Drawing Title
**FIGURE 6.8
HILTON PARK 1842**

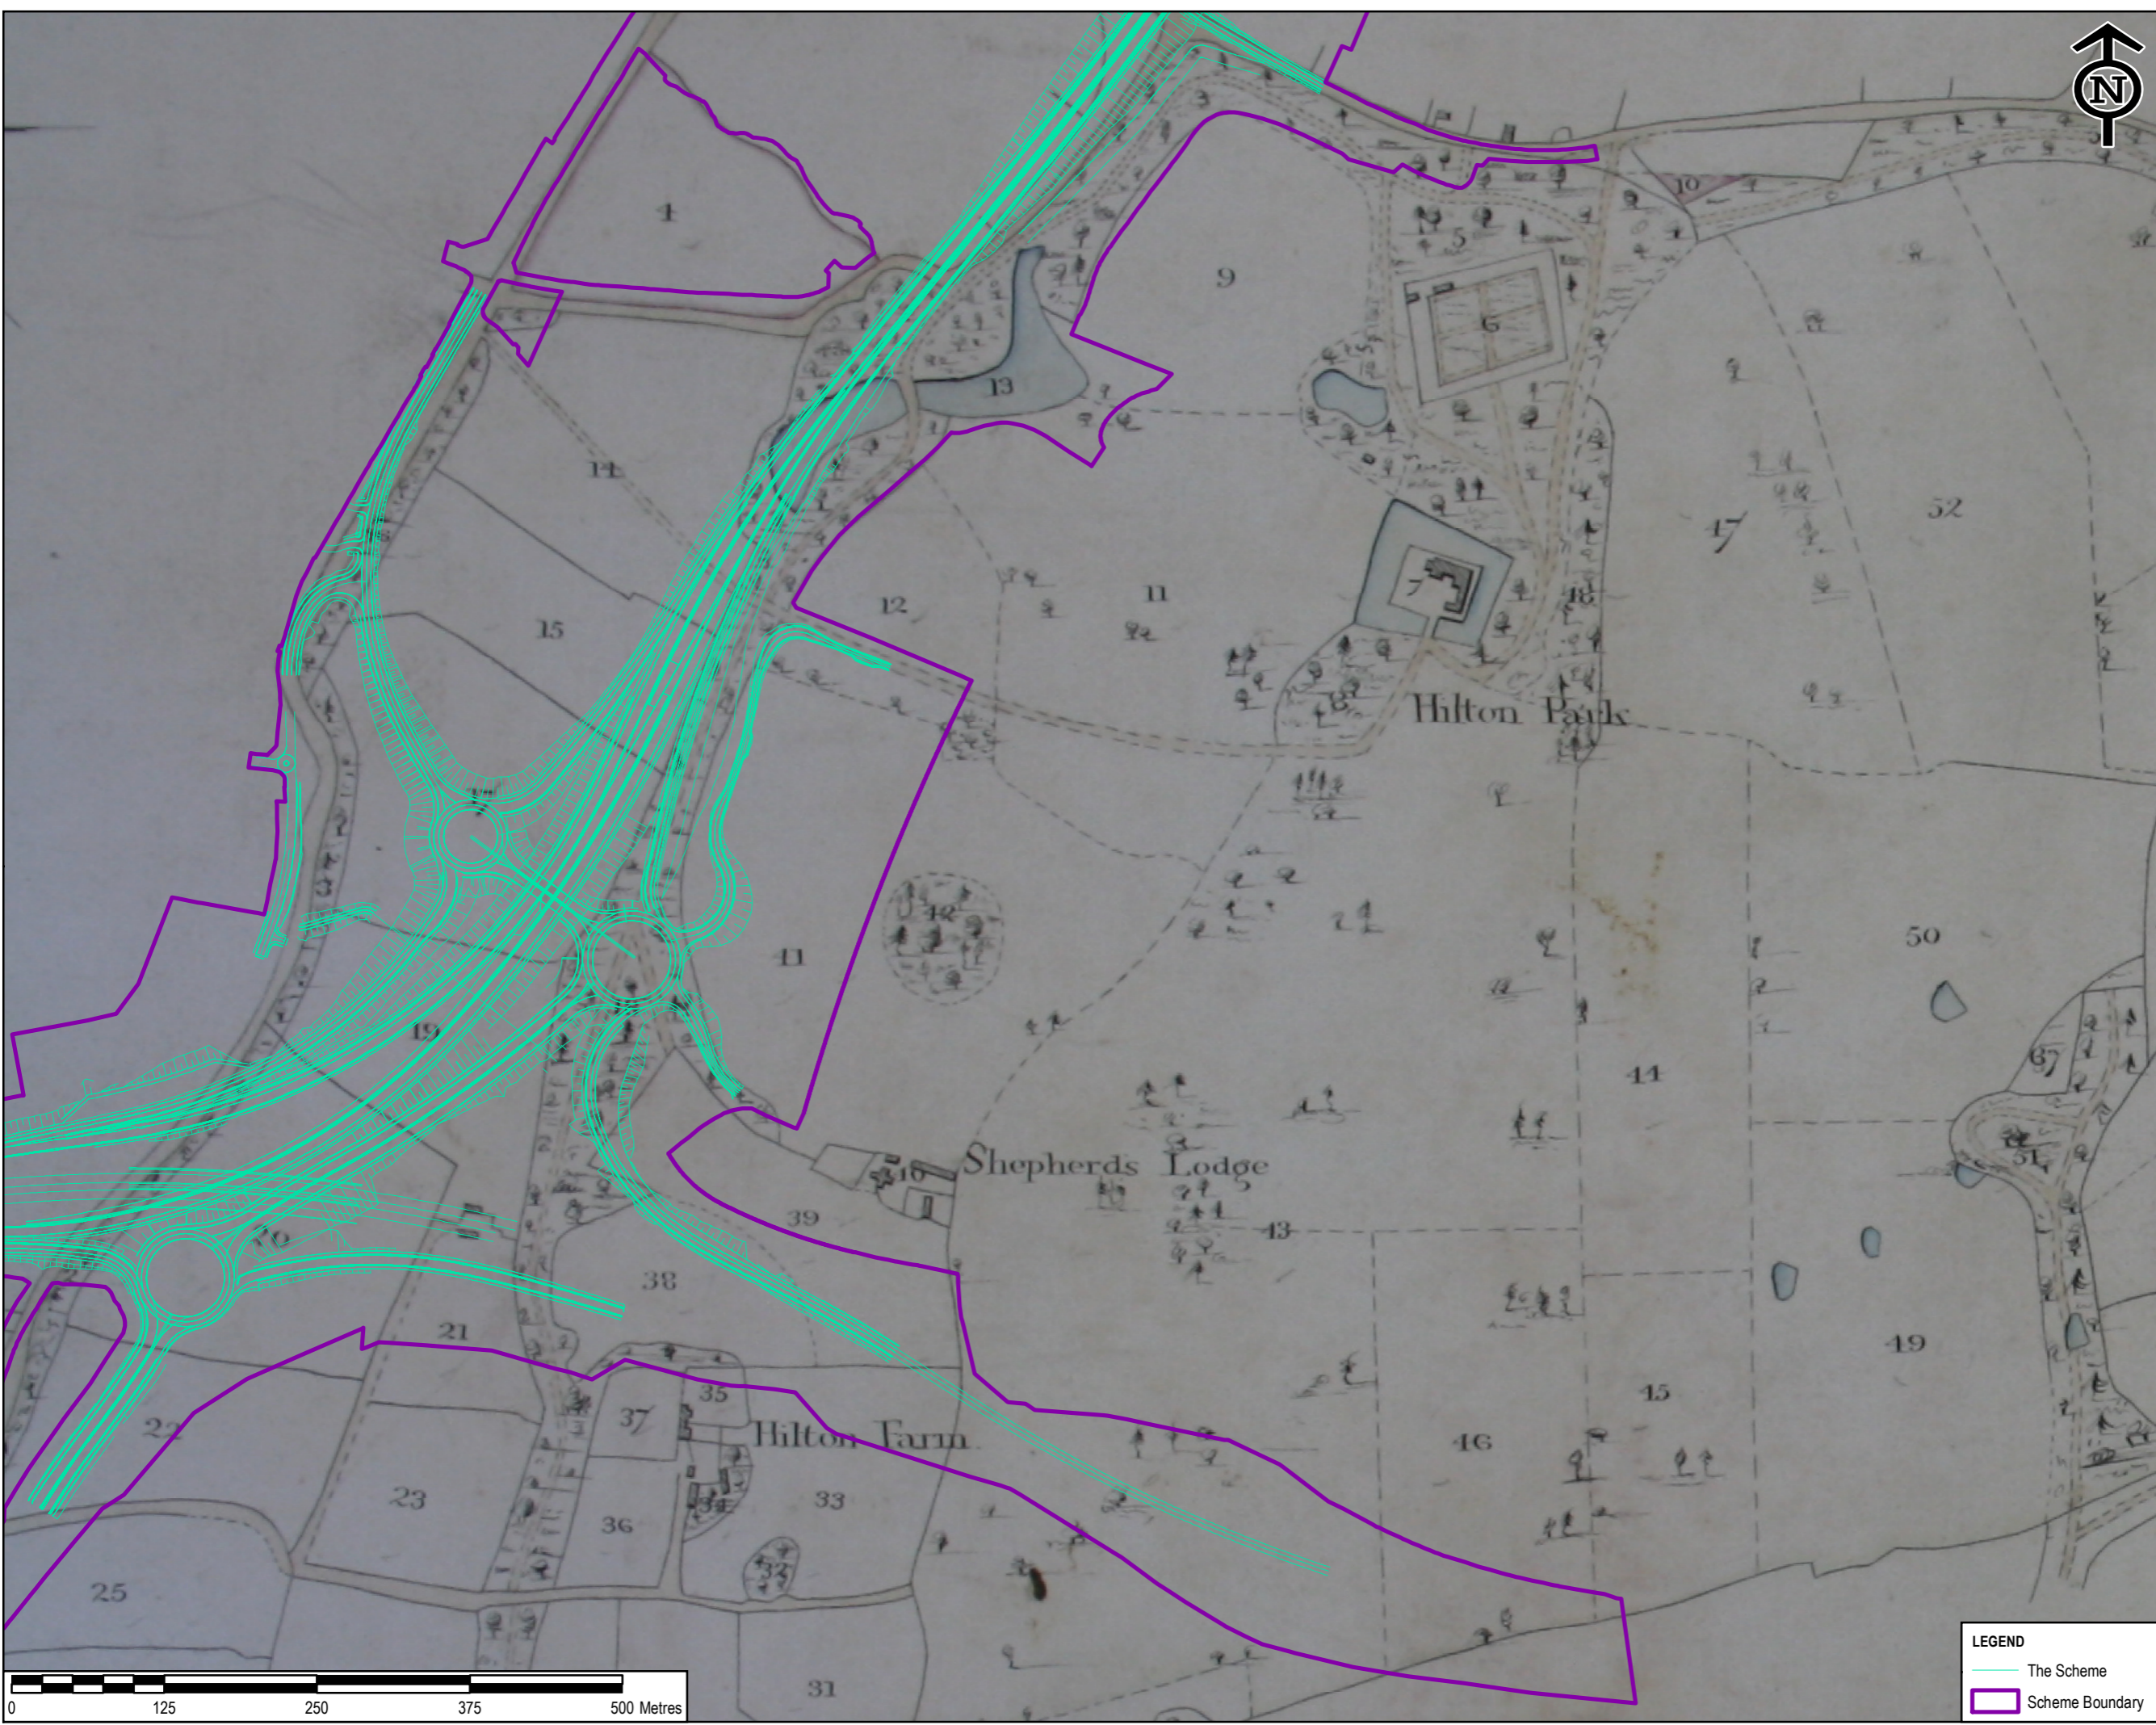
3.6.3	The Applicant SCC SSC RCHME Allow Limited	Hilton Park In its paper on Assessment of Alternative Locations for Mitigation in Plot 5/2 submitted at D4 [REP4-036] the Applicant appears to accept that Hilton Park was designed by Humphrey Repton. (a) Is this a fair summation of the Applicant's view? (b) If Hilton Park was designed by Humphrey Repton does this make any difference to the consideration of the Proposed Development?	SCC is happy to defer to RCHME and South Staffordshire Council's Conservation Officer on this matter.
